Your Ref: OWPC20007
Our Ref: AW/210/18/HH 24-07-2018
Please ask for:
Samantha Allen

Front porch, entrance gate & piers.
1 Raycroft Close Bognor Regis

PLAN 1-100

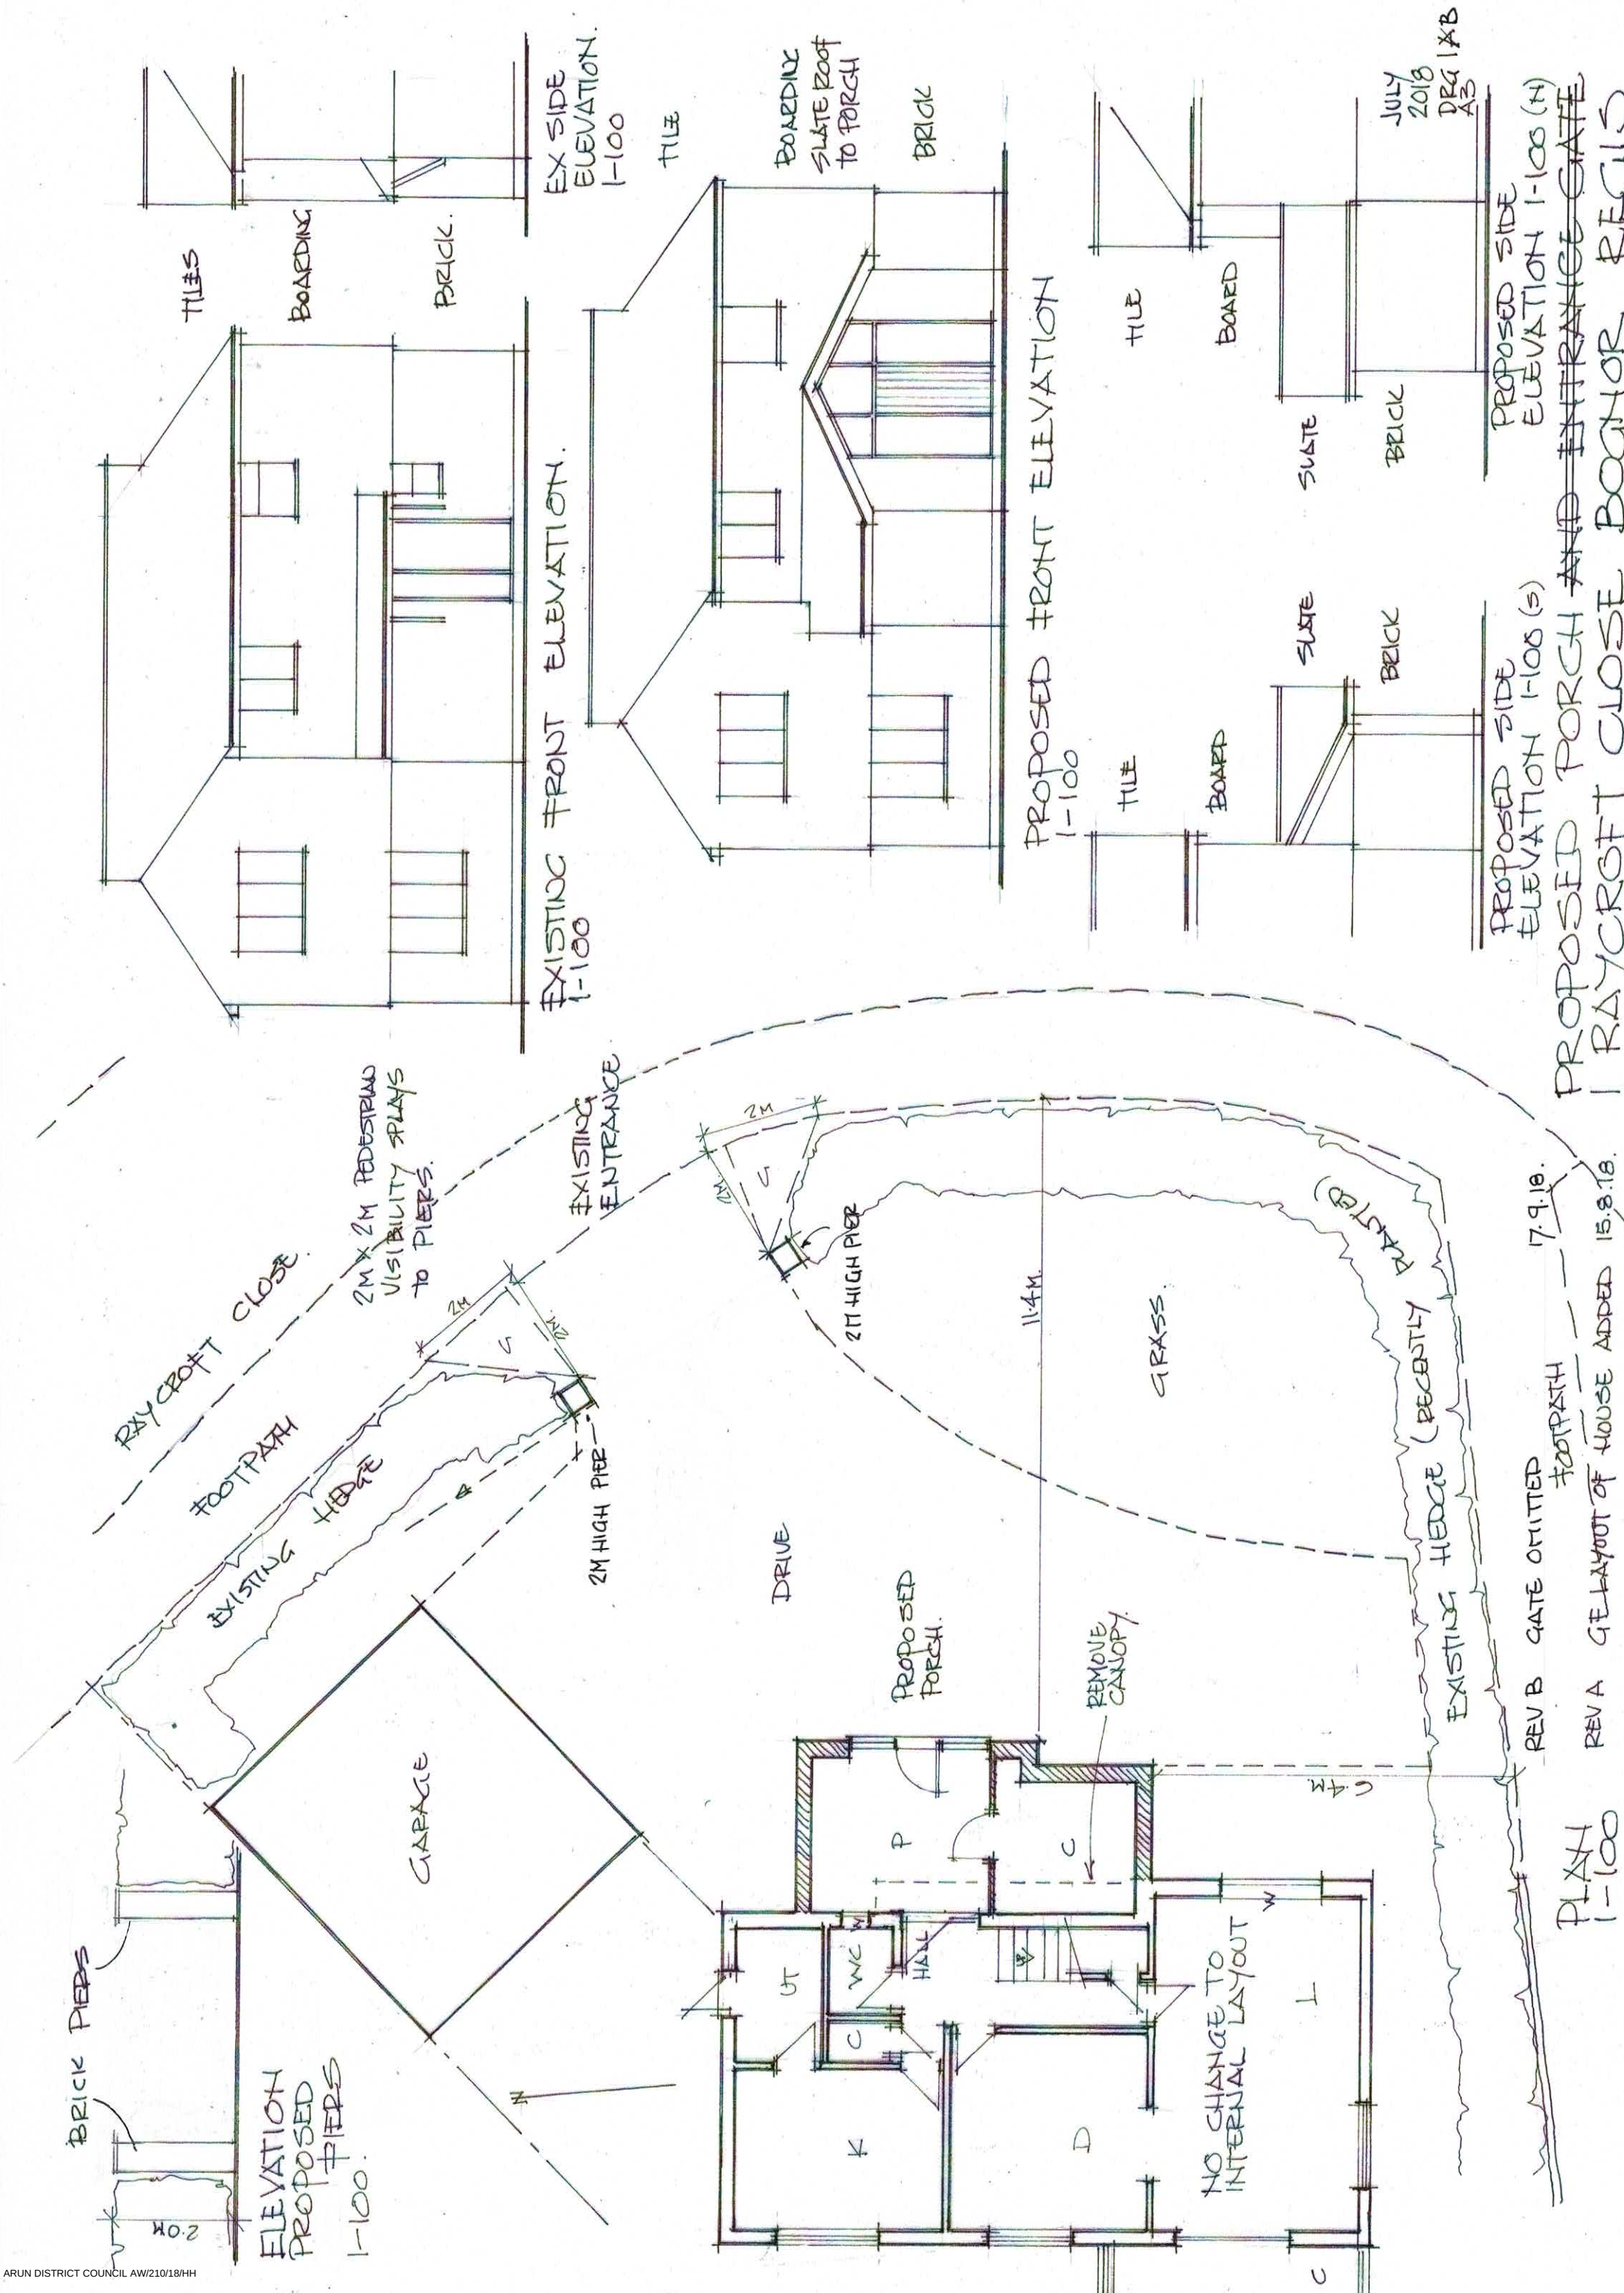
As one cannot cherry-pick parts of a Planning Application, although I have no objection to the porch, I wish to object to this planning application on the grounds that the proposed gate will destroy the open-planned nature of the original estate which consisted of the roads Chawkmare Coppice, Wyde Feld, Raycroft Close, Faresmead and Mauldmare Close.

There are two further points that I would like to raise, the first is that of road safety because the gate will provide a blind spot for motorists travelling in either direction, as the house is on a corner. Secondly, I think that this structure will prove to be detrimental to the area and possibly lower the value of other properties in the area.
